COMMUNITY SERVICES DEPARTMENT

April 27, 2022

Subject: Rolling Hills Ranch North Early Grading and Erosion Control Plan Review (EGP-22-002)

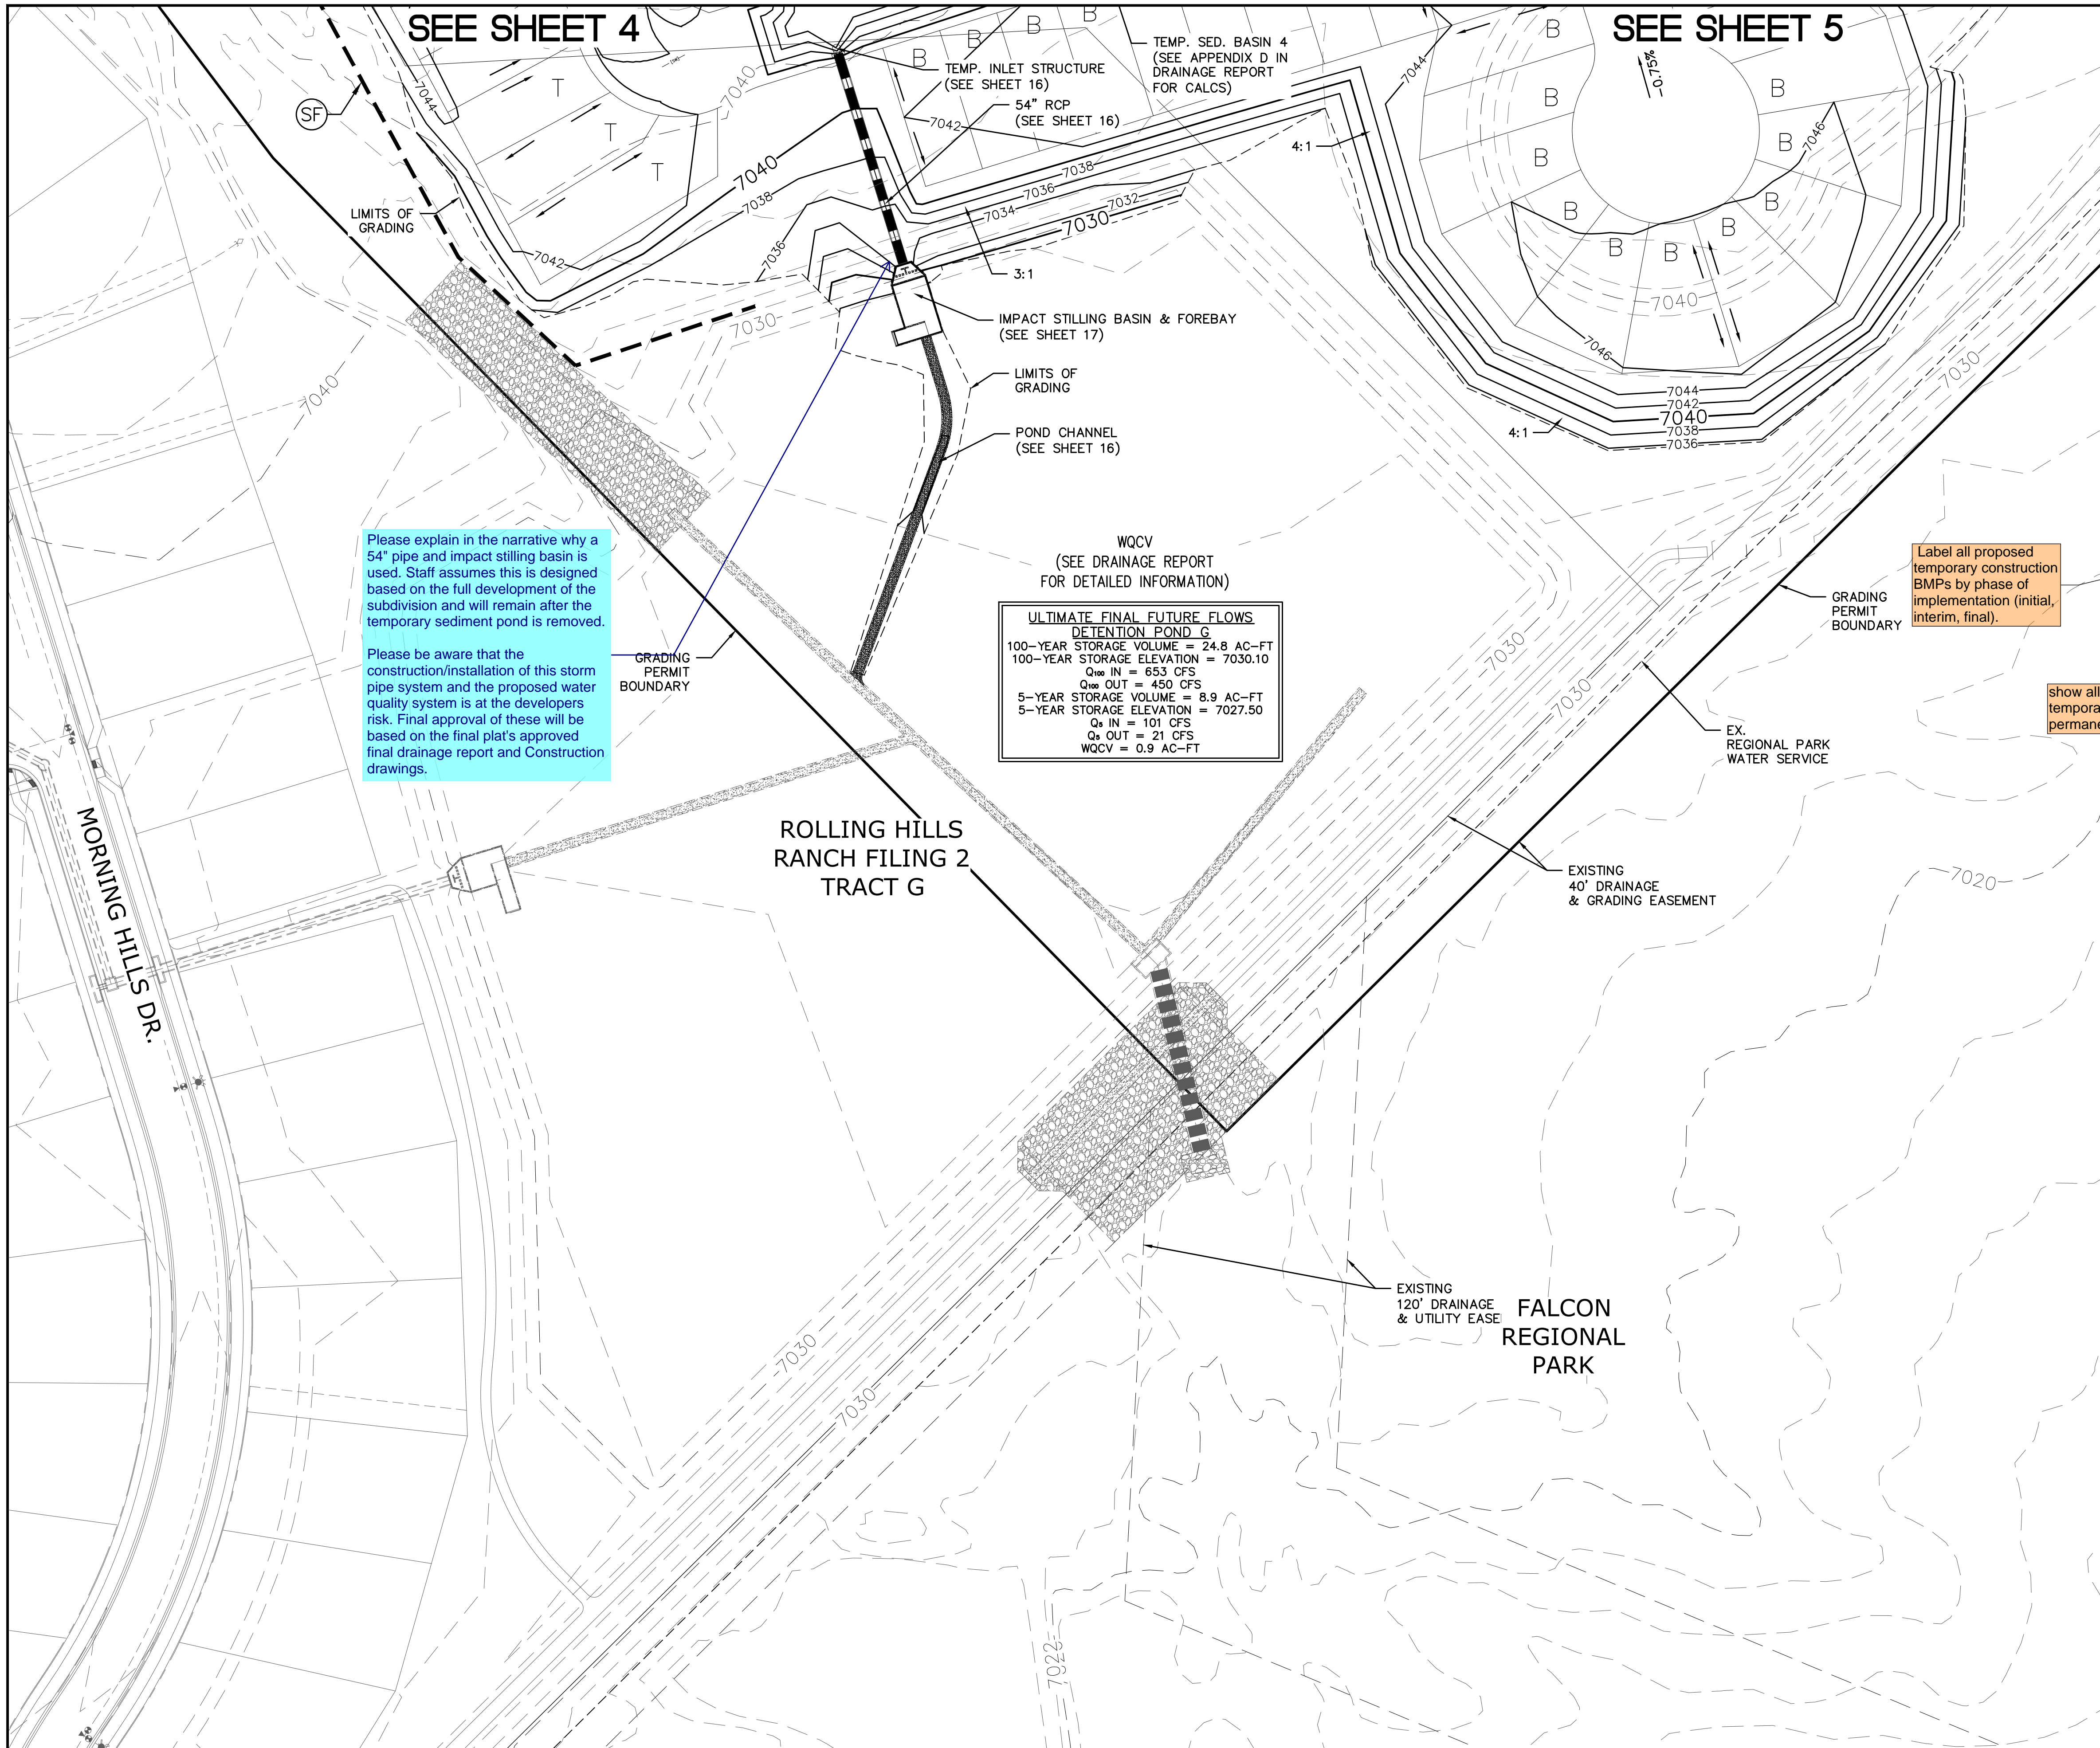
As shown on Sheet 3 of the Early Grading and Erosion Control Plans, the applicant plans to install a large stormwater detention facility, referred to as Pond 3 at a location immediately adjacent and west of the southern portion of Falcon Regional Park. Staff appreciates the location and magnitude of this facility, as excessive stormwater runoff from the planned residential community could have a negative impact on the sensitive natural drainage environment downstream of the pond. This facility should have negligible impacts on the recreational components of Falcon Regional Park.

Drawn by	LOG	Checked by	TAK	Date	MARCH 2022
Scale	AS SHOWN	11	of 23

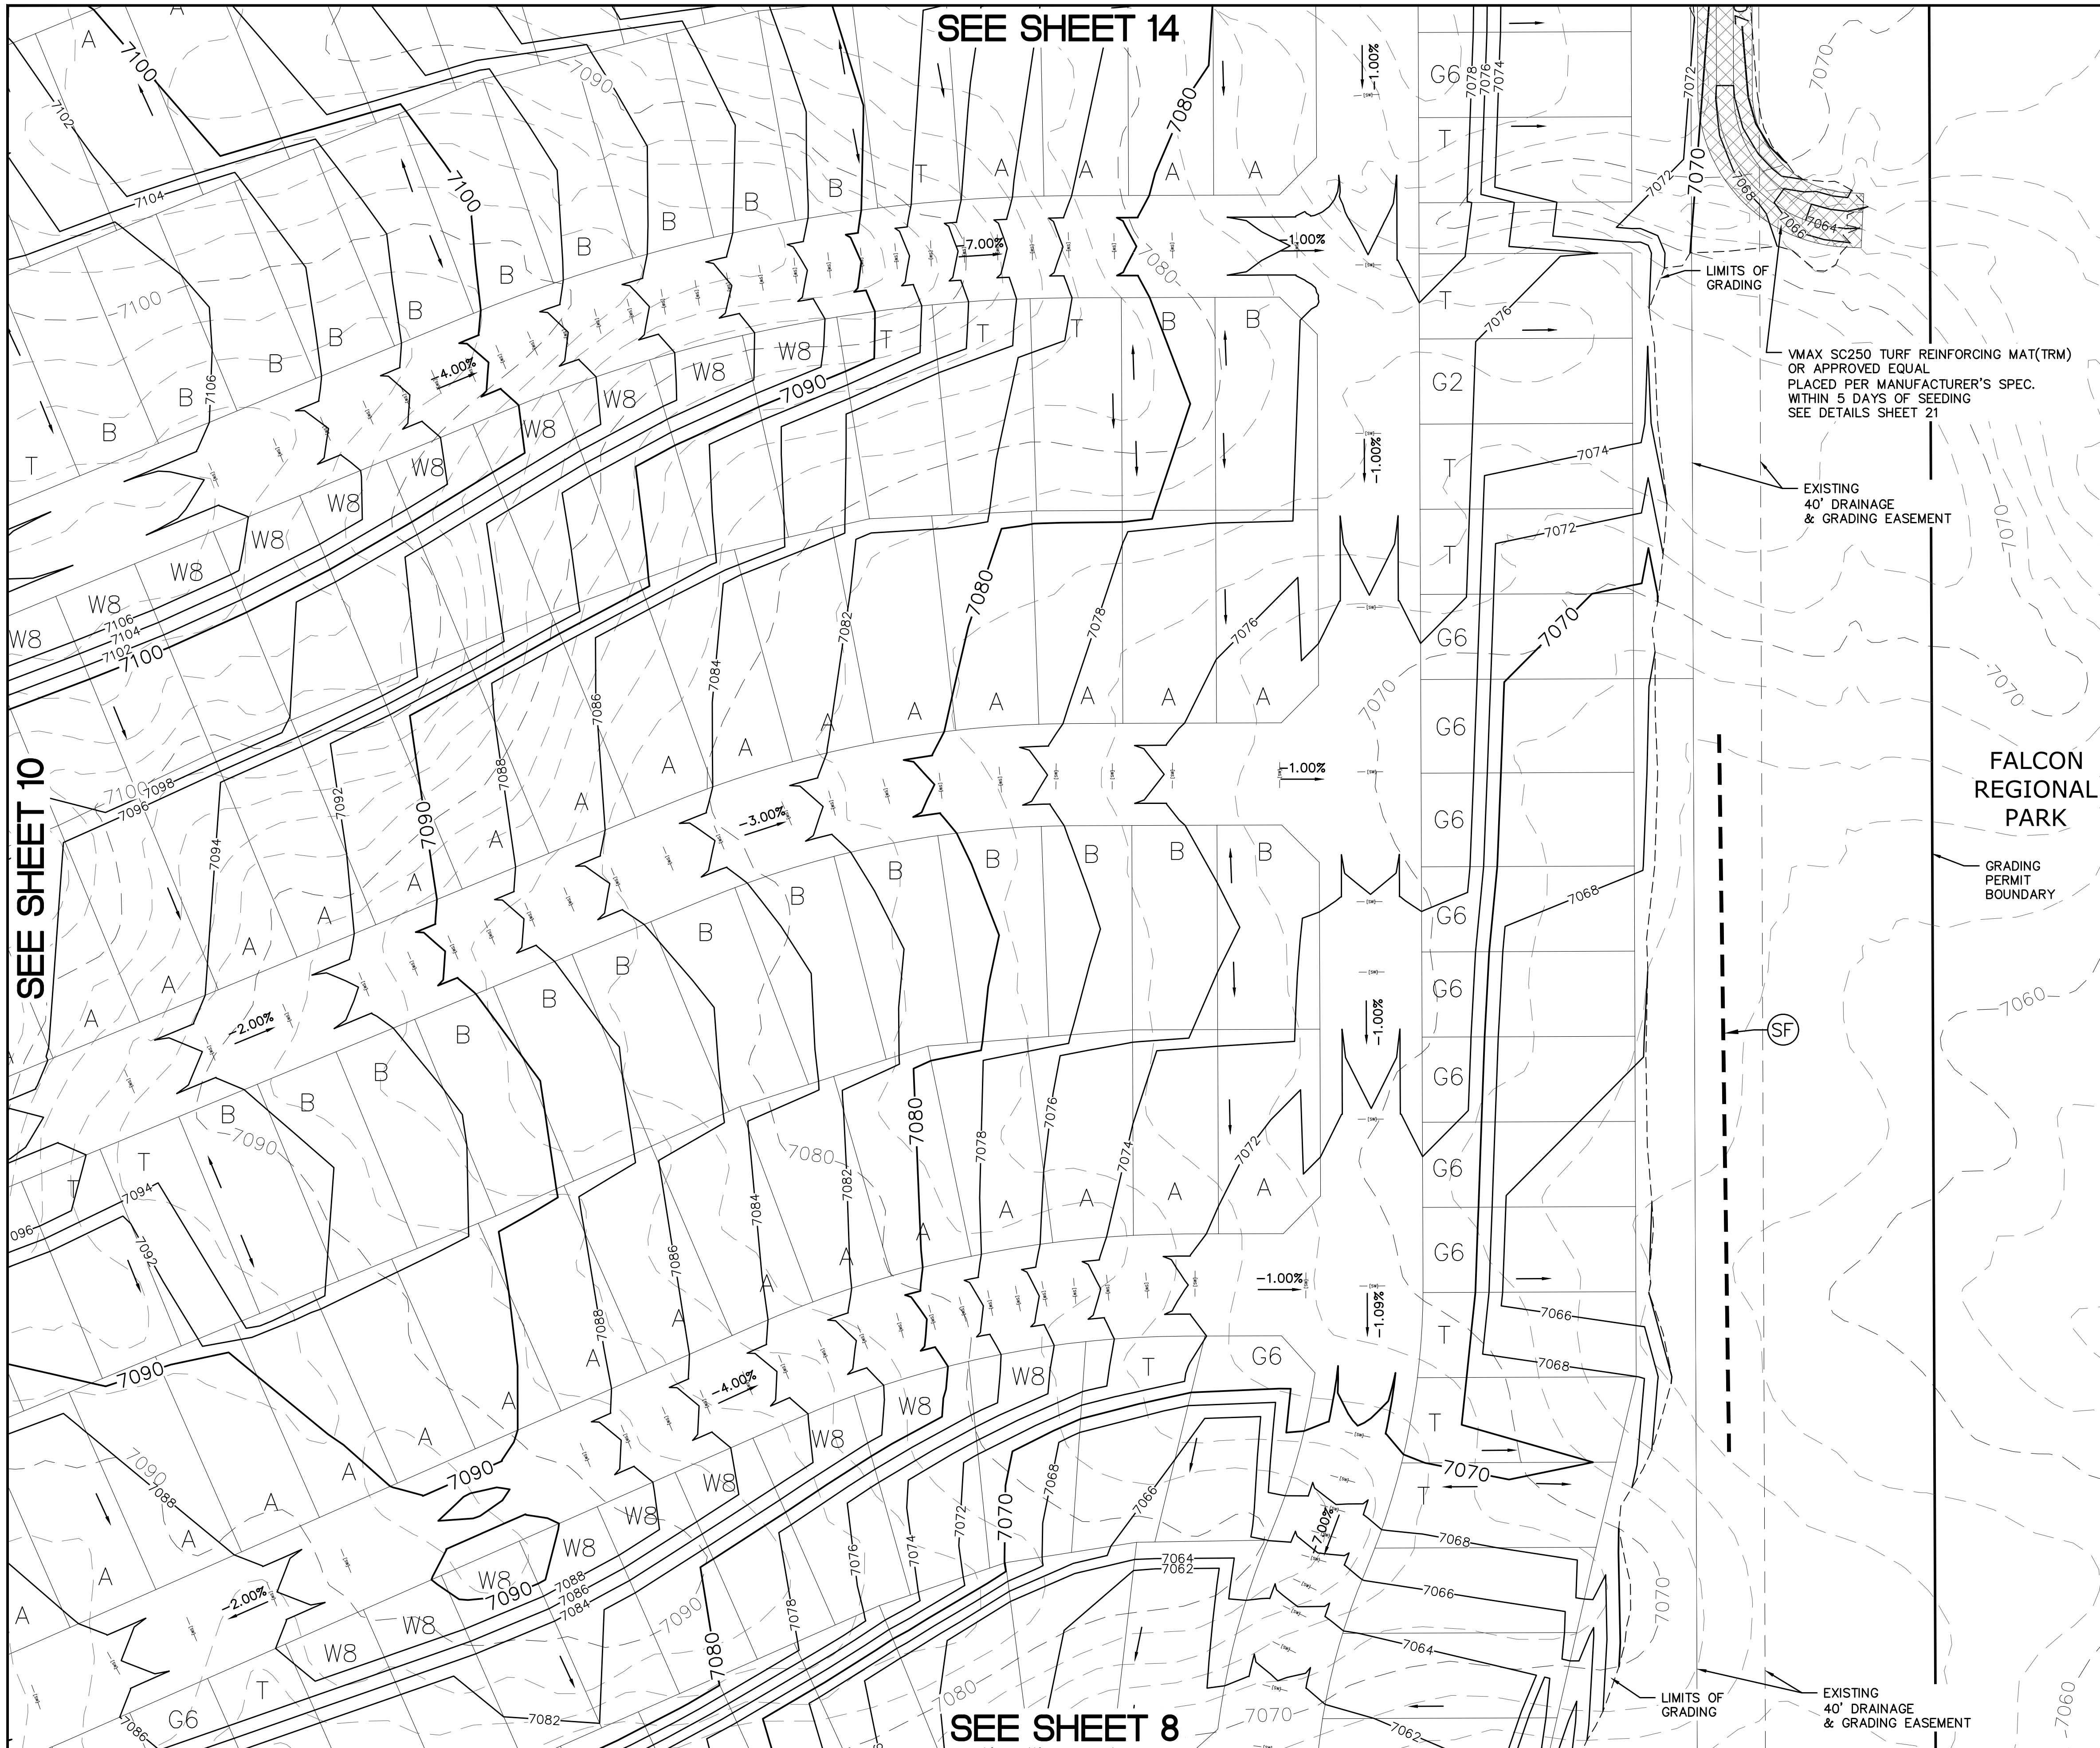
However, Sheets, 11, 13, and 14 of the Early Grading and Erosion Control Plans shows 25'-40' wide drainage channel being constructed along the northern boundary of the proposed residential lots of Rolling Hills Ranch North, within the bounds of 54-acre Hydrologic Element HG-13. This drainage facility channels overland runoff eastward then southward into an existing natural drainage channel in Falcon Regional Park. The plans do not show any stormwater detention facilities along the channel's path, and therefore it can be assumed that stormwater runoff will have a direct path into the natural drainage channel in Falcon Regional Park. This natural channel proceeds southeastward through the park's passive-use open space areas and will be routed under the proposed Rex Road extension, before exiting the park under Eastonville Road, east of the main parking area. Staff is concerned that this unimpeded drainage channel will allow for a higher discharge velocity and could greatly impact the natural drainage in the park, creating a higher risk for flooding and erosion in what has proven to be a sensitive environment that does not respond well to extreme stormwater runoff events. Staff requests the applicant demonstrate that flows from this drainage channel will not negatively impact the natural or recreational values of the park.

Furthermore, while the 40' Drainage and Grading Easement allows for the construction of drainage facilities within its bounds, the aforementioned drainage channel does extend beyond the easement boundary and into Falcon Regional Park by an estimated 50 feet. The proposed drainage channel should be removed from County Property and located on the applicant's property as there is no documented easement providing for infrastructure within the park outside of the already provided drainage and grading easement.
